Re: Serenity Trails Subdivision – PA24-001 – Technical Review 1
3209 83rd Ave NE – APN(s) 00590700028500

SUBDIVISION COMMENTS

RE: Serenity Trails Subdivision, File# PA24-001

**PRELIMINARY PLAT MAP**

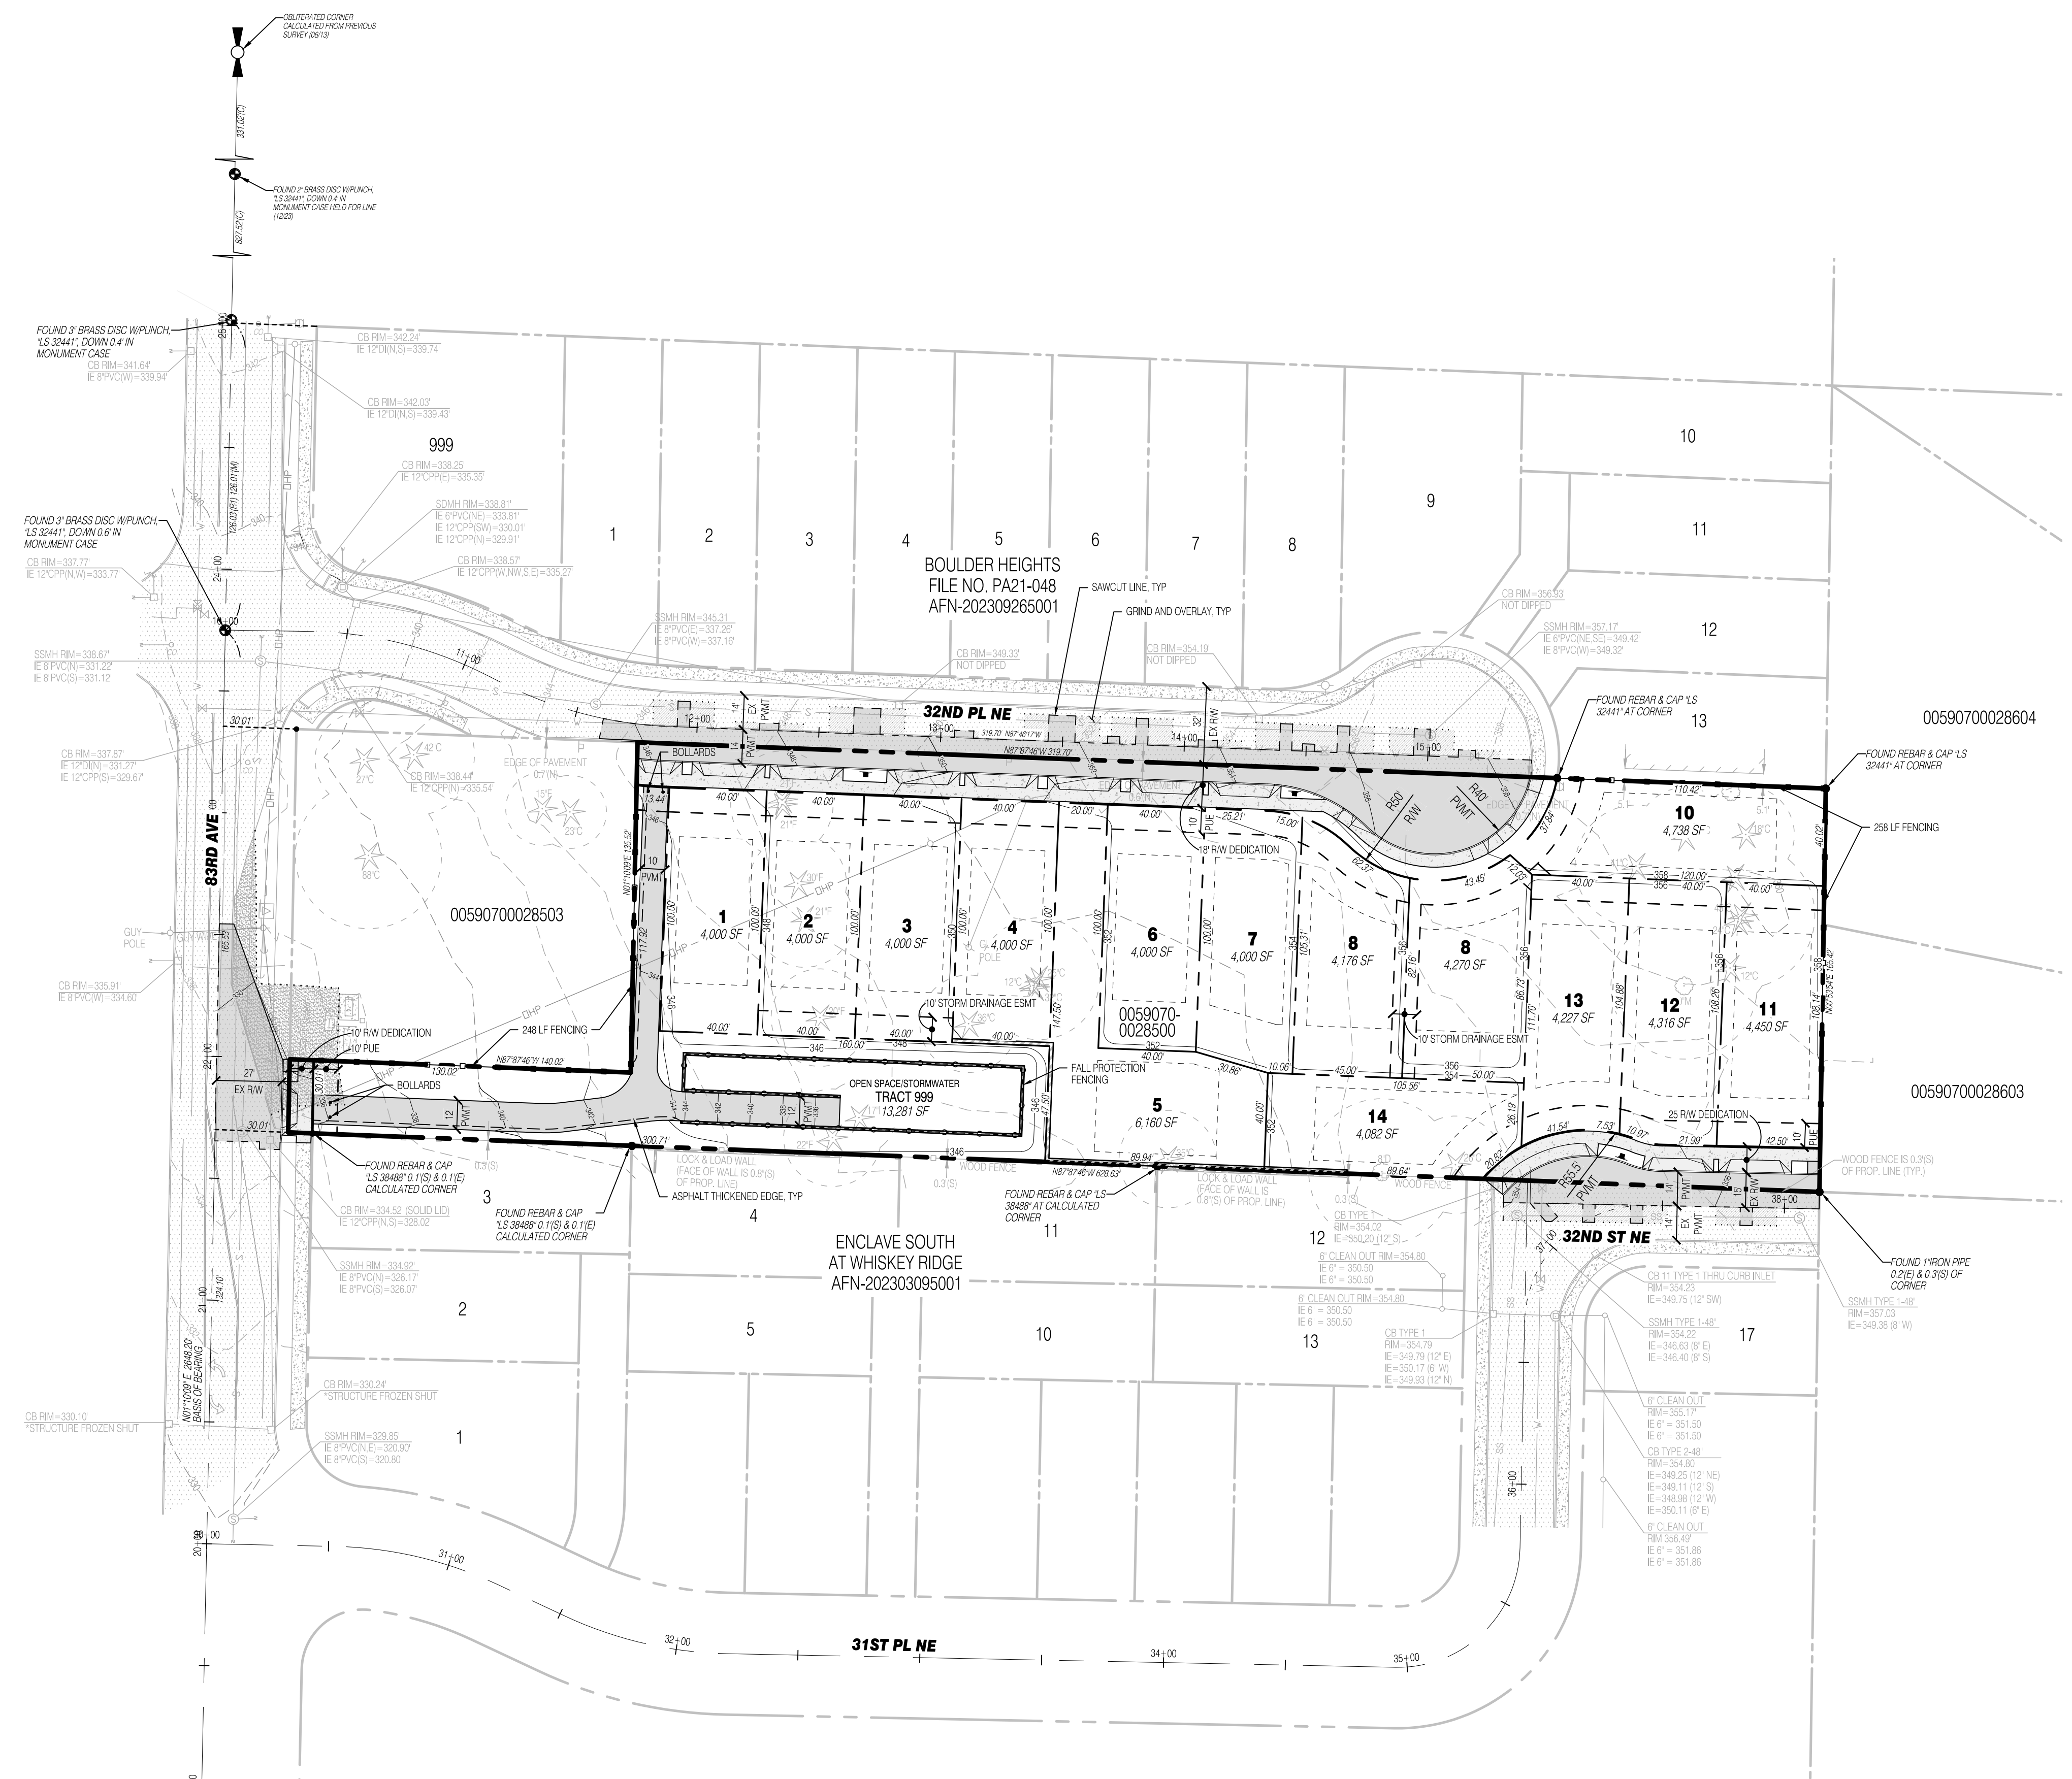
5. Please determine whether the new lots (including the stormwater tract) along the south property line of this development would be higher than the abutting lots of the Enclave South at Whiskey Ridge. If so, please demonstrate compliance with the provision by adding the required 6 ft. fence to the proposed plans.

7. To ensure compatibility with the neighboring Boulder Heights development (North), please include the use of Pyramidal European Hornbeams for proposed street trees.

8. Stormwater management facilities are required to have a 5ft. L5 landscape buffer. Planting areas may incorporate no more than 30 percent deciduous plantings due to maintenance and pond performance constraints. Please provide confirmation that the proposed planted buffer would meet this standard.

- a. Frontage improvements will be required along 83rd Ave NE to be built compliant with SP 3-201-004 with a 6’ sidewalk.

4. **Dedication Requirements:**
 - a. It appears that 83rd Ave NE will require an additional 10' of right-of-way to be dedicated.

- a. **Lots 11, 12, 13, and 14 will require 13D fire sprinklers due to single point access from 83rd Ave NE per MMC 9.04.503.1.5 Exception 1.**
- b. **Lot 5 will also require a 13D fire sprinkler due to distance from ROW per EDDS 2-060.D.12.**

- f. The minimum required fire flow for dwellings exceeding 3,600 SF is 1,500 gpm.
- g. Maximum hydrant spacing for the proposed SF use is 600 ft. *Plan show 2 hydrants on 32nd Pl NE in acceptable locations. GIS shows another hydrant located along 84th Dr NE which would serve lots 11-14.*

PP-01
3 OF 8

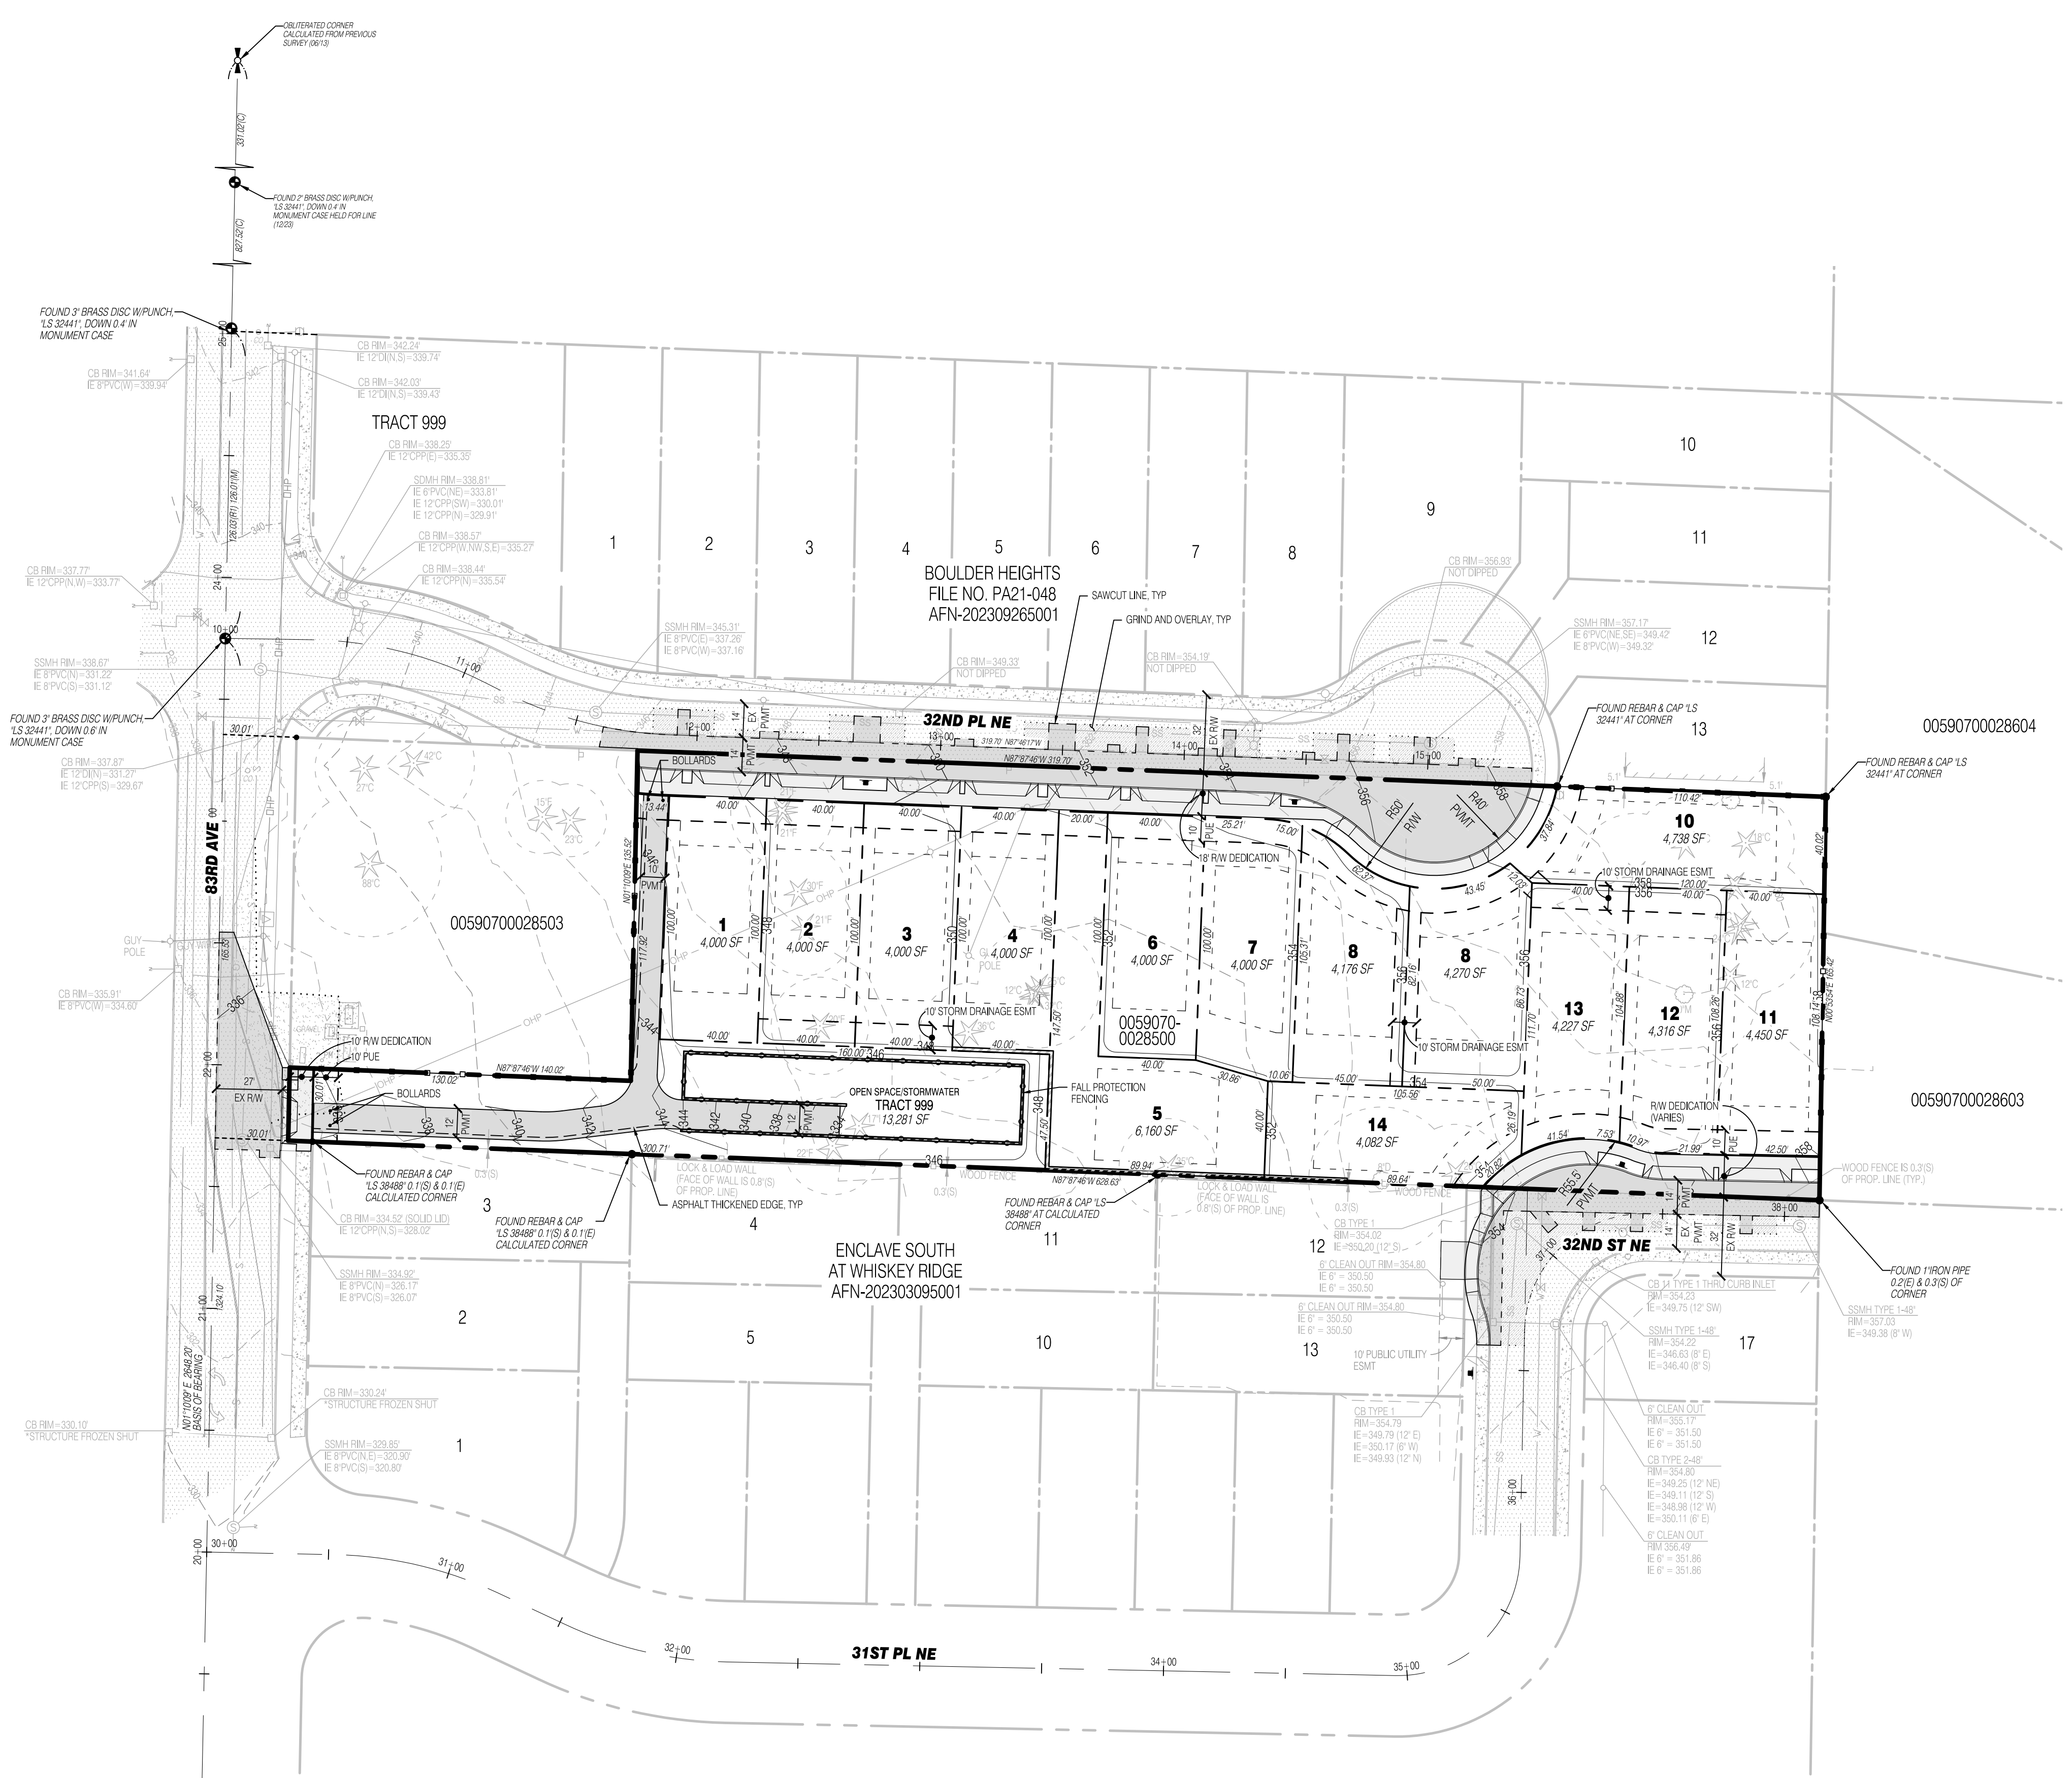
- i. Single family homes Trip Generation shall be 1 PM peak Hour trip per unit consistent with development of Traffic Impact Fee (TIF) calculations.
- 3) Undergrounding of existing overhead utilities along frontage of 83rd Ave NE shall be required.
